From: Planning
Subject: FW: 3/2021/1164

From: Billington and Langho Parish Clerk <blparishclerk@outlook.com>
Sent: 11 December 2021 10:01
To: Planning <planning@ribblevalley.gov.uk>
Subject: 3/2021/1164

Proposed Site Plan

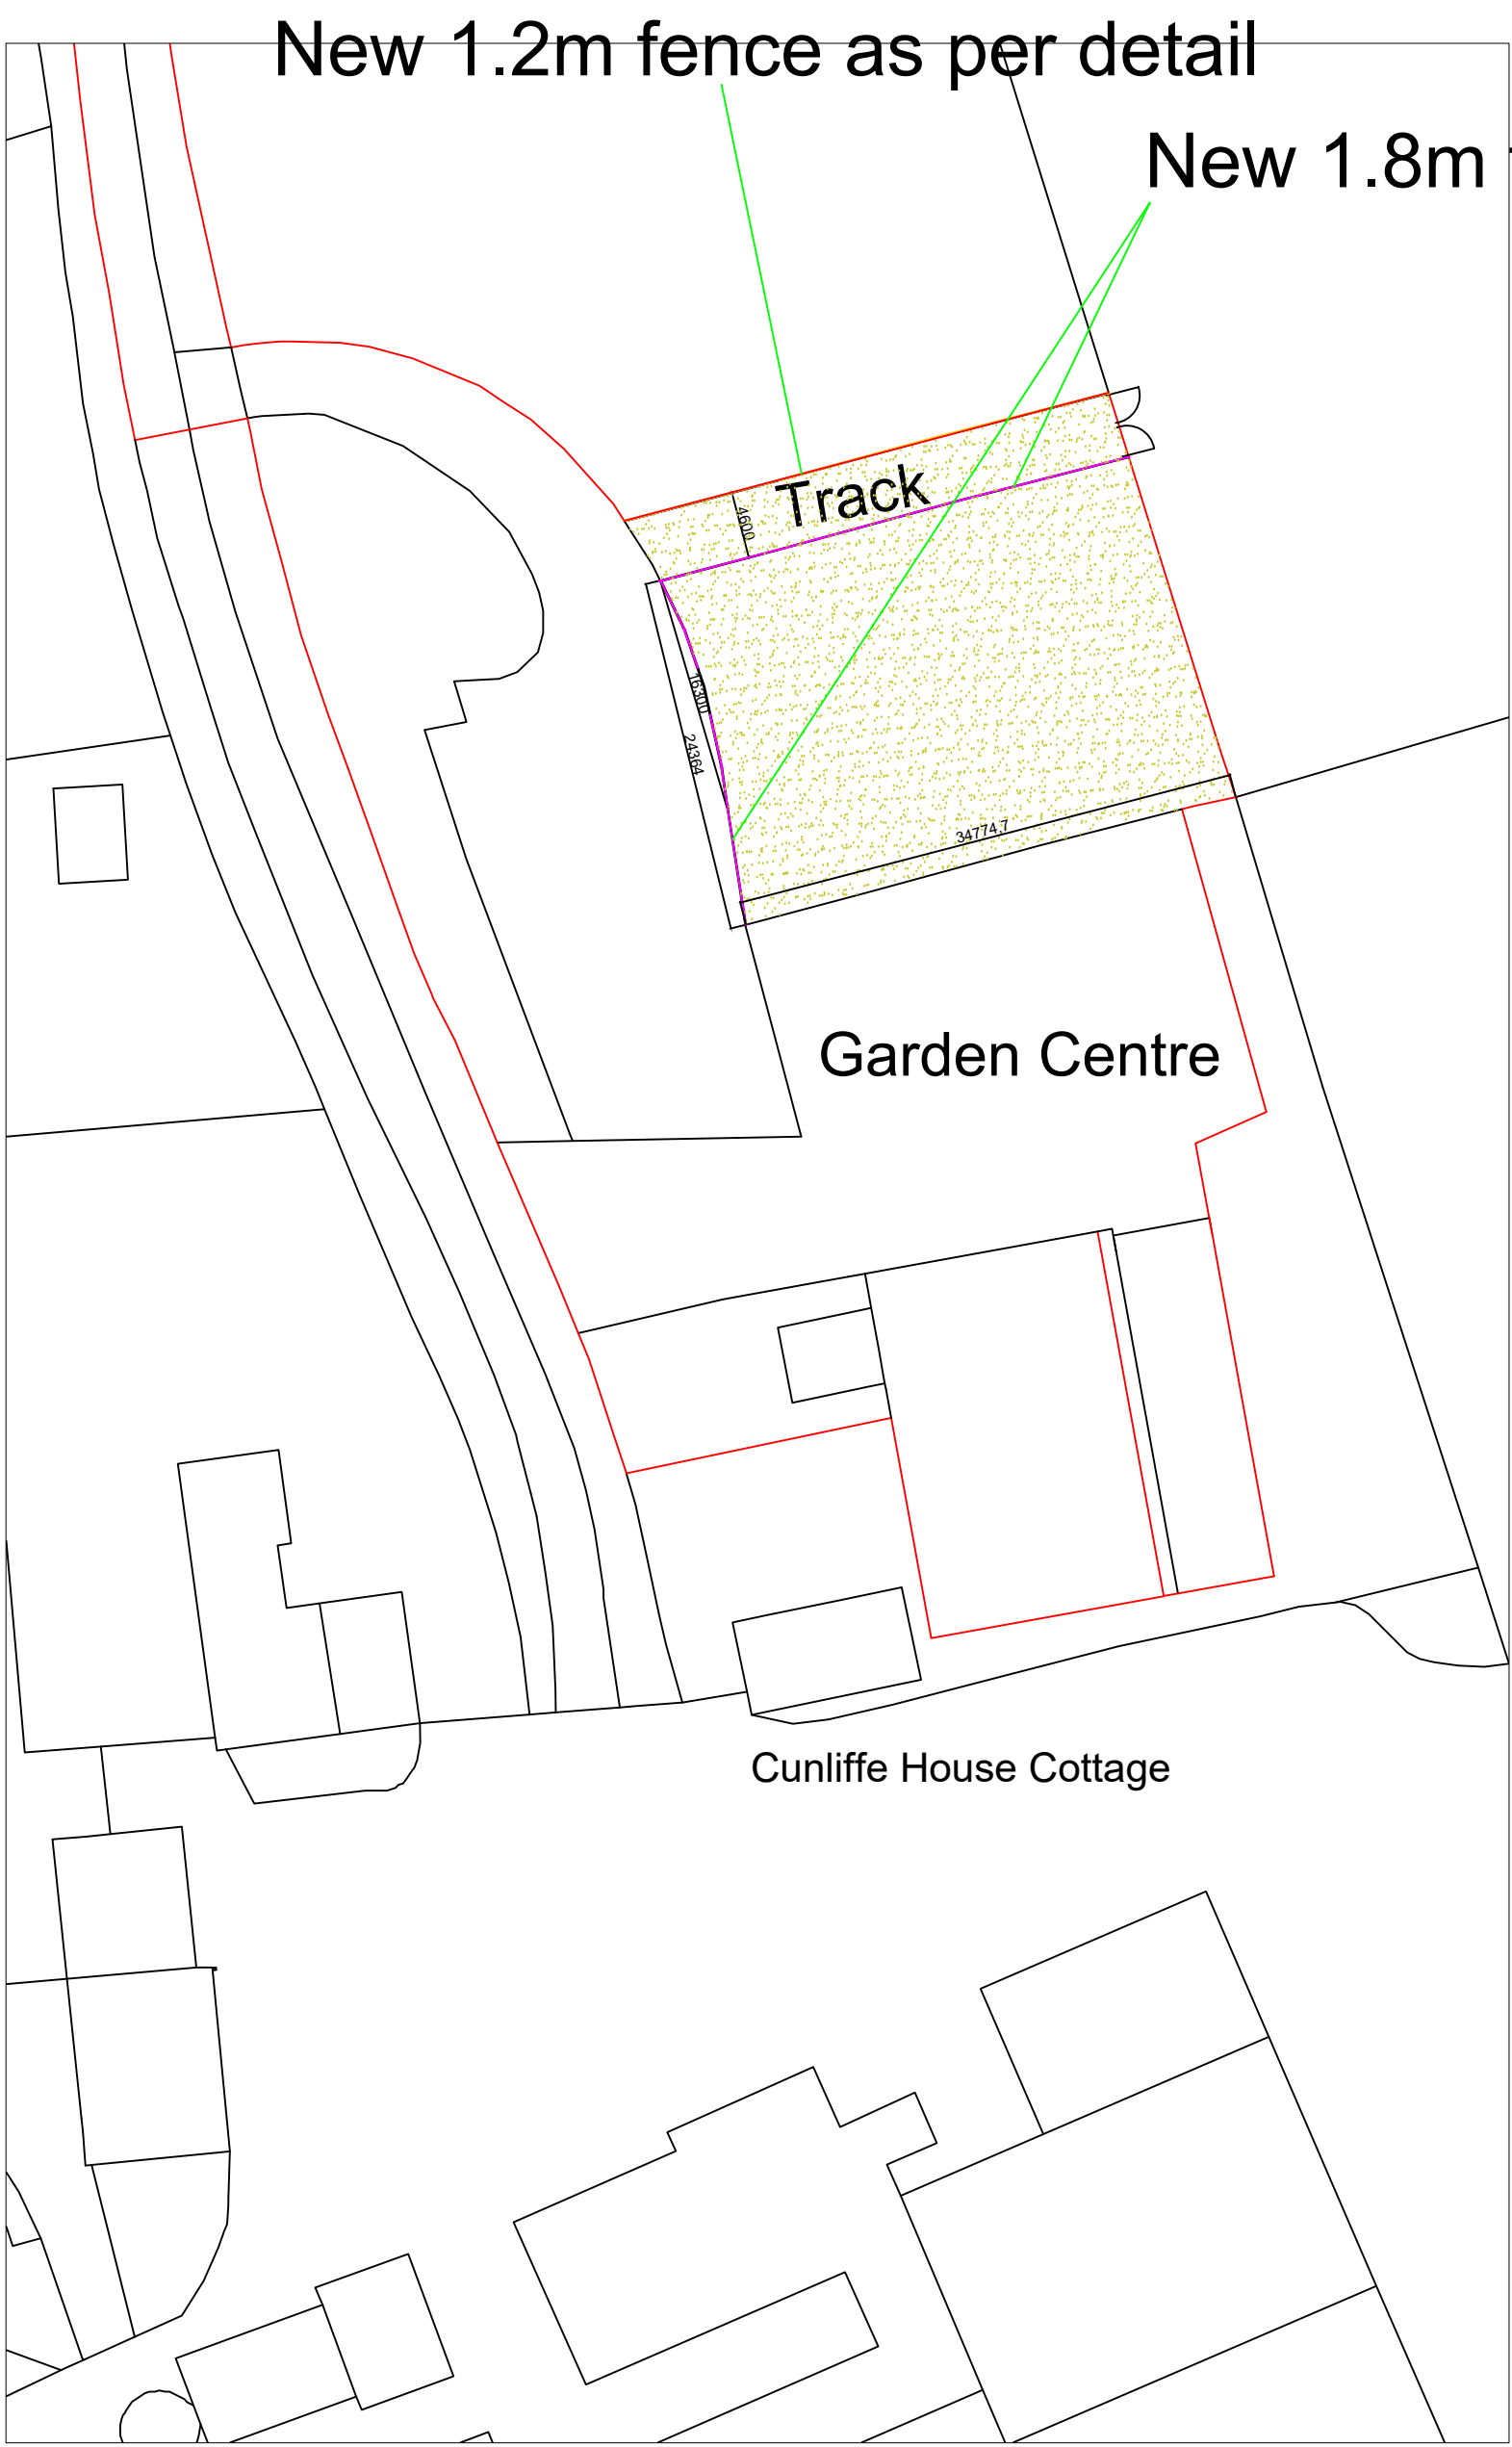
Further to consultation with members of the parish council, I and wanting to encourage local businesses, concerns have been raised that this appears to be extending the garden centre towards the A59. At the moment, despite the big advertising signs, the garden centre is set well back from the road and passing vehicles get virtually uninterrupted green fields until the new development at Northcote. If it were to be approved, could we ask for it to be fully screened by trees/bushes?
